Planning Application Reference No.: 3/2025/0027

Address of Development: Colliers Farms Whalley Old Road Billington BB7 9JF

FLOOR PLAN

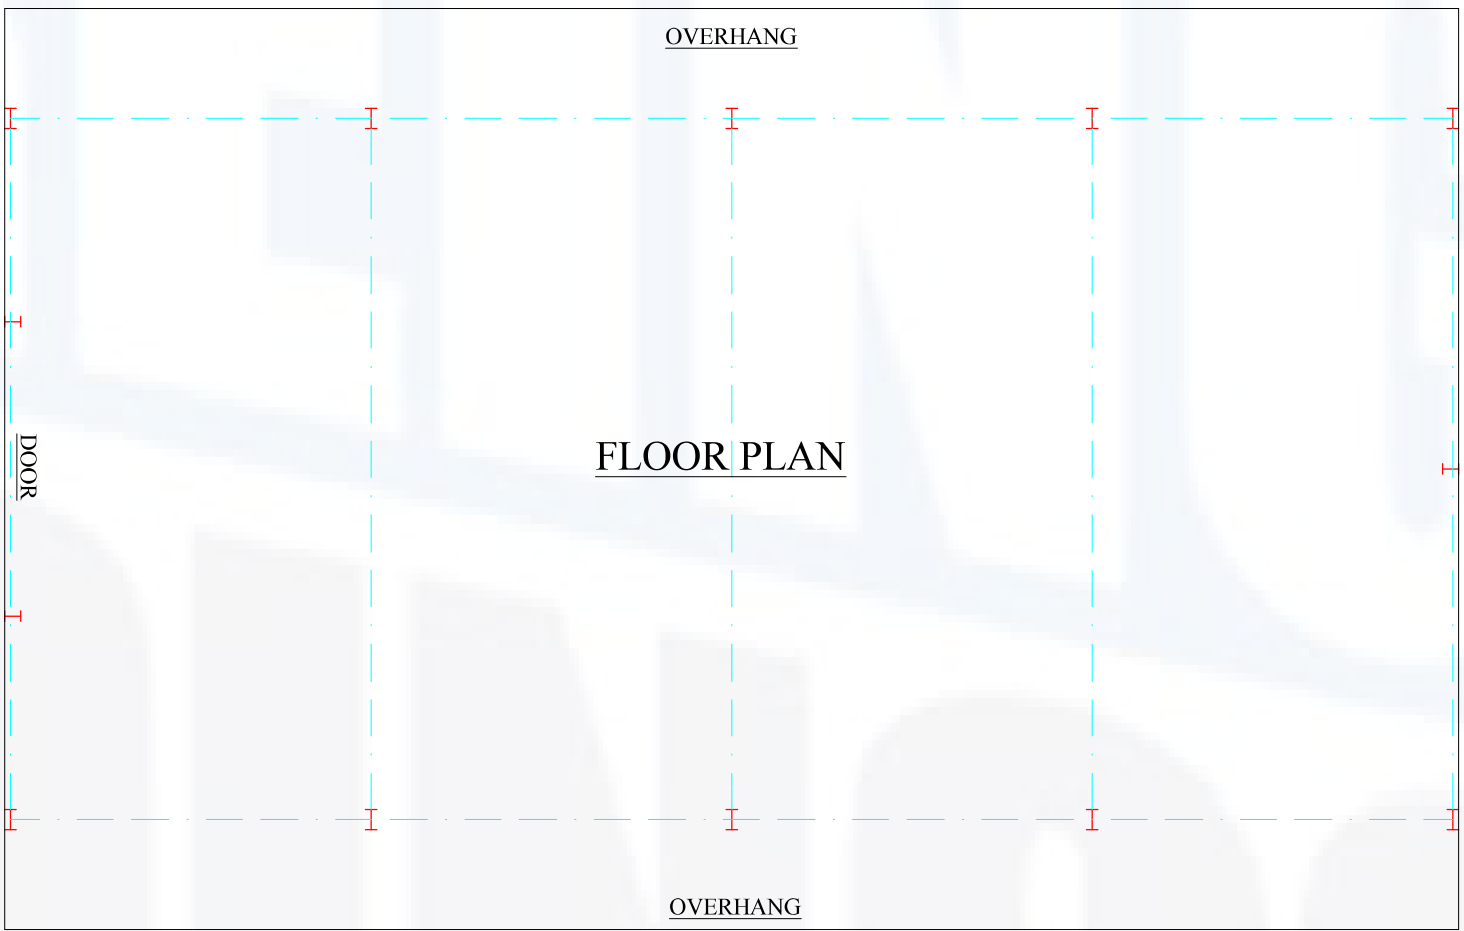
Comments: Construction and future usage (heavy vehicle traffic) of this agricultural building poses a risk to our main water supply pipe which runs in the vicinity of the site. We would appreciate a confirmation on how this will be addressed and secured both during the construction and after. We would also appreciate if the owner would confirm they will take accountability to ensure no adverse effect on the water supply and pressure during and after the construction.
